Department for Transport

Date: 29 October 2021

Application by Highways England (“the Applicant”) for an Order granting Development Consent to authorise the widening of an approximately 20.6km stretch of the existing A1 between Morpeth to Ellingham, with approximately 14.5km of online widening and approximately 6.1km of new offline highway (“the Proposed Development”).

REQUEST FOR COMMENTS FROM THE APPLICANT AND NORTHUMBERLAND WATER (“NW”), NORTHERN POWERGRID (“NPG”), NORTHUMBERLAND COUNTY COUNCIL (“NCC”), MR HAWES AND MR DAVIDSON.

Figure 5 - Alternative Route B

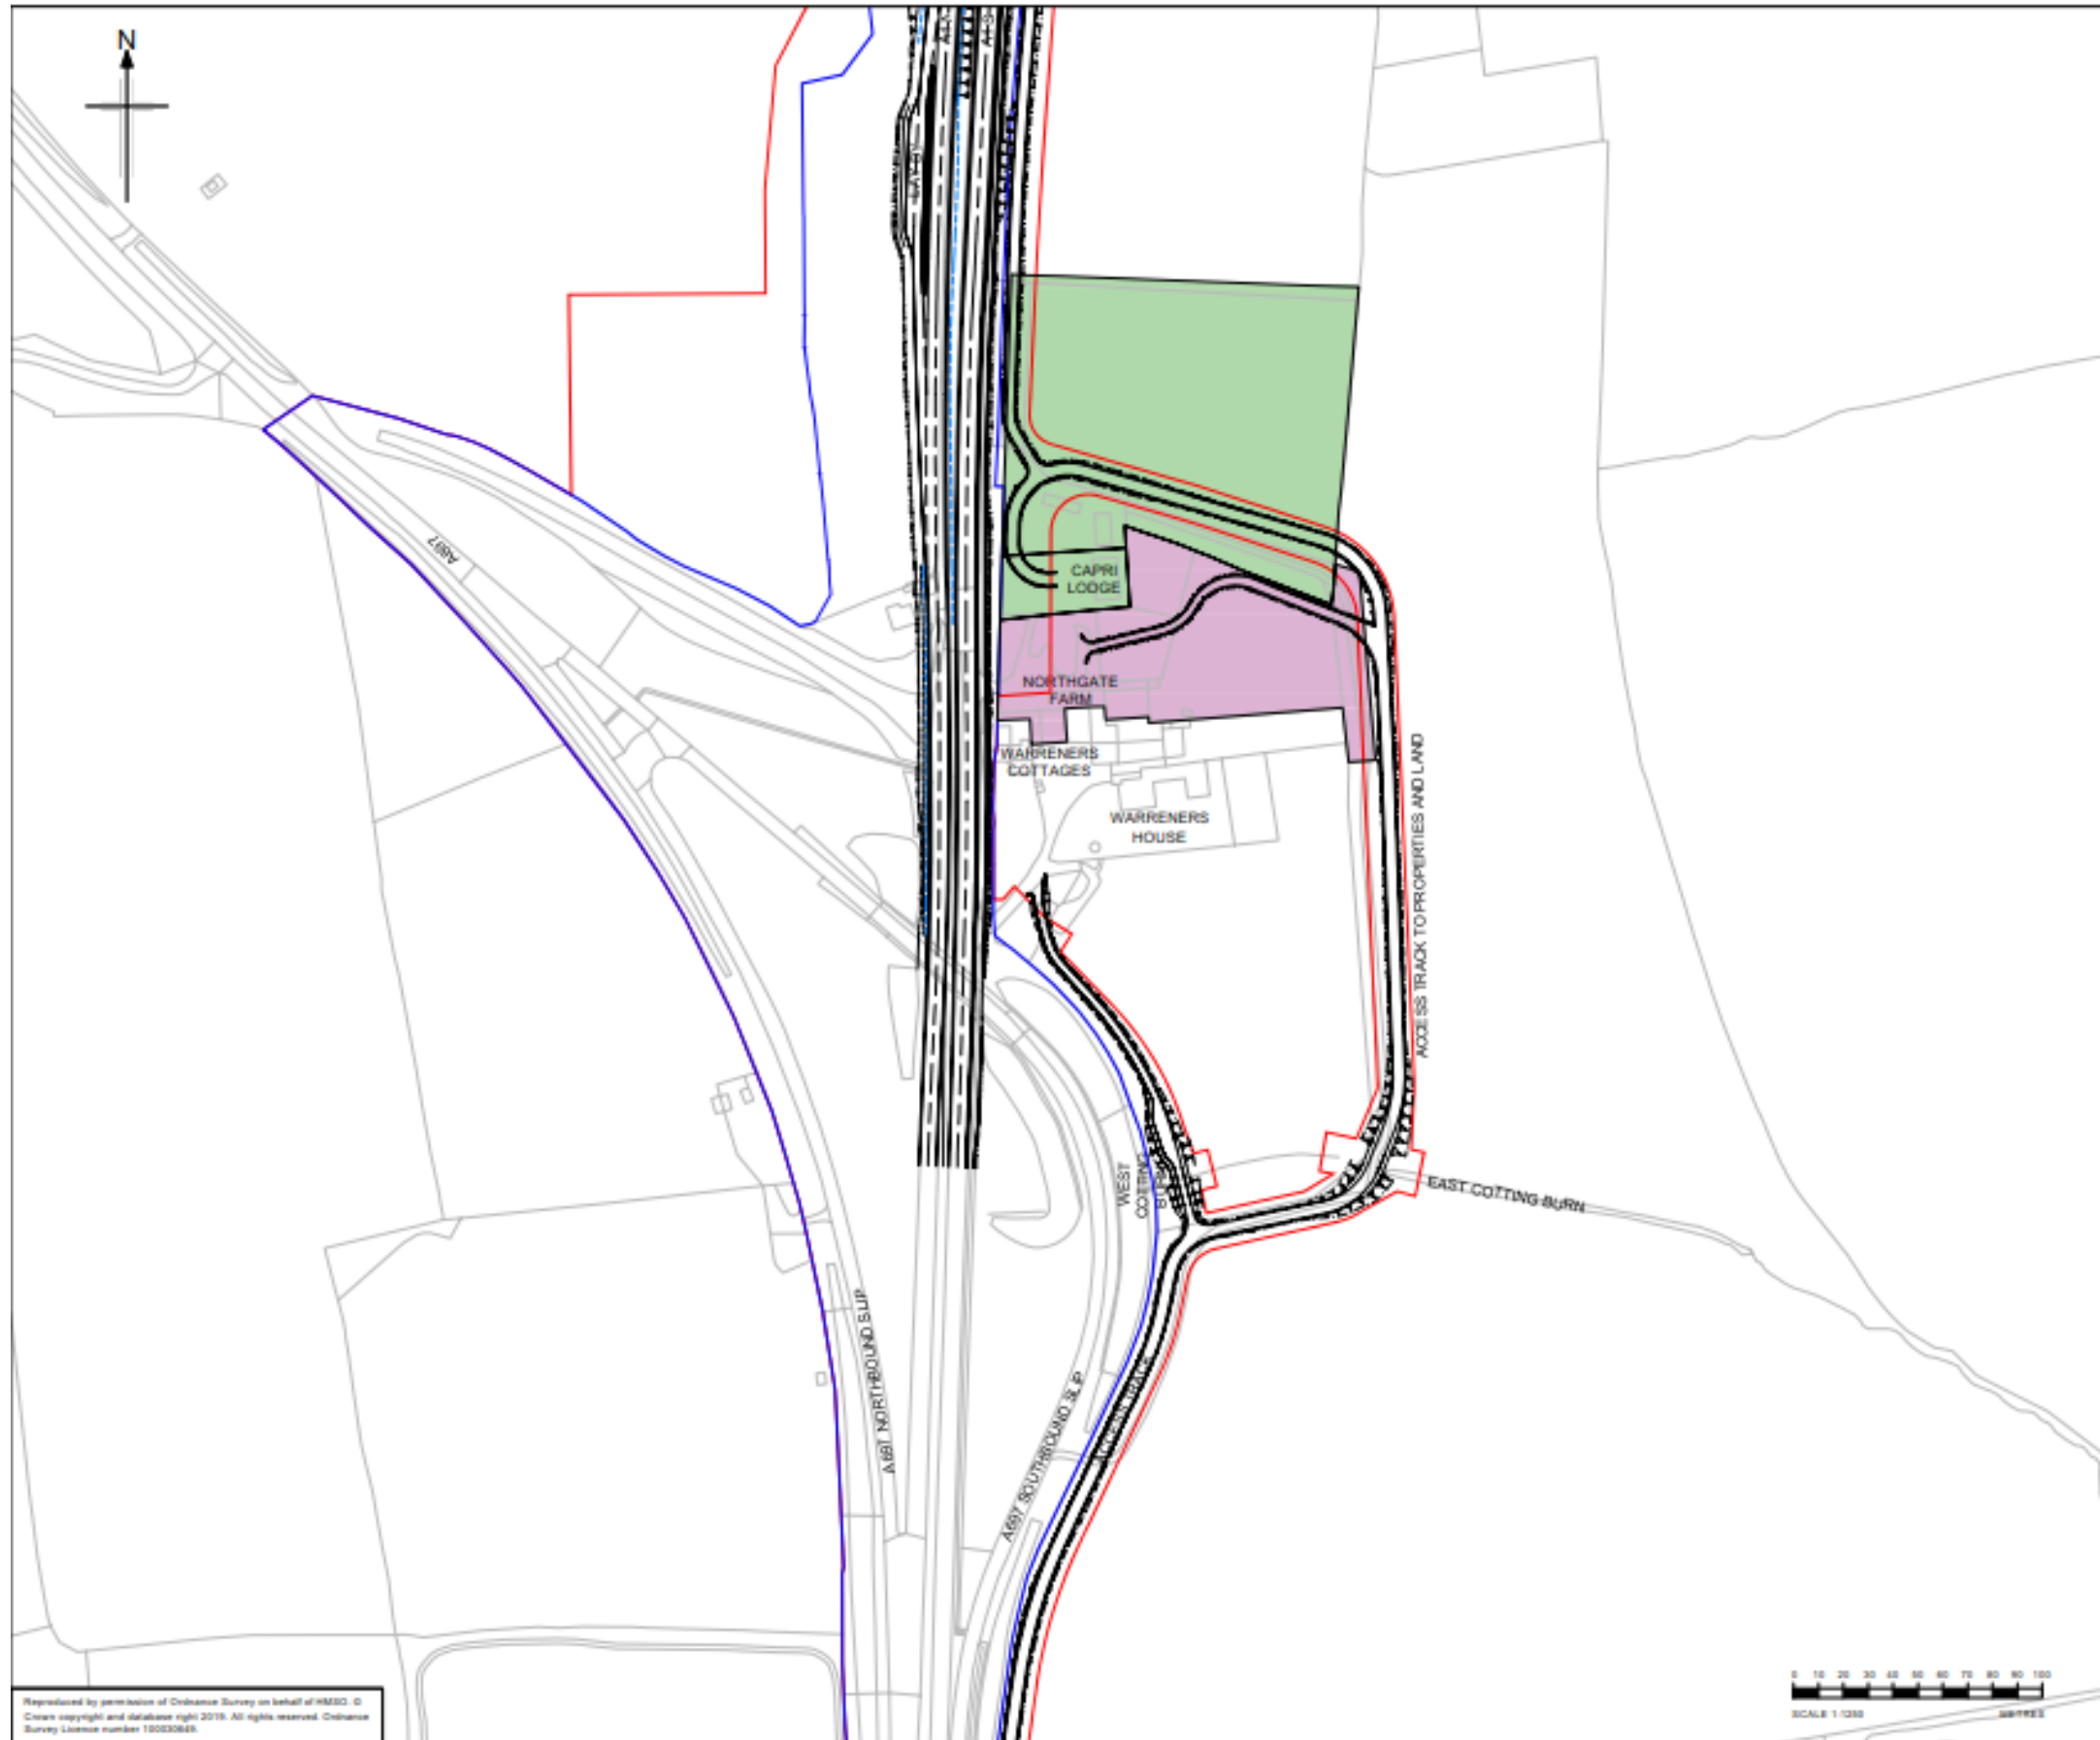
The Secretary of State notes the Applicant's position on the replacement access that would be provided to Northgate Farm and Capri Lodge [\[REP10-37\]](#).

Please could the **Applicant** and **relevant interested parties (including Mr Hawes on behalf of residents of Northgate Farm and Mr Davidson)** comment on the status of any further discussions about the location of the access track, and in particular on whether any agreement has been reached as to its location.

In order to provide the three alternatives in the DCO that were considered during the examination, the Secretary of State is minded to include a revised description of Work No. 5b in Schedule 1 to the proposed development consent order as follows:

Work No. 5b - a new access track being one of—

Work No. 5b(a) 832m in length to the north of the West View turning circle commencing at grid reference 418259E; 5888134N and terminating at grid reference 418254E; 588647N; or

Work No. 5b(b) 677m in length to the north of the West View turning circle commencing at grid reference 418259E; 5888134N and terminating at grid reference 418342E; 588723N; or

Work No. 5b(c) 552m in length to the north of the West View turning circle commencing at grid reference 418259E; 5888134N and terminating at grid reference 418391E; 588764N.

Please could the **Applicant**:

- (a) confirm whether the specifications of the grid references and track lengths are accurately reflected in the three options that were under consideration during the examination;
- (b) confirm that each of the options would be deliverable under the development consent order; and
- (c) provide revised versions of the relevant sheets of the Works Plans and Land Plans to show any changes that would be required?
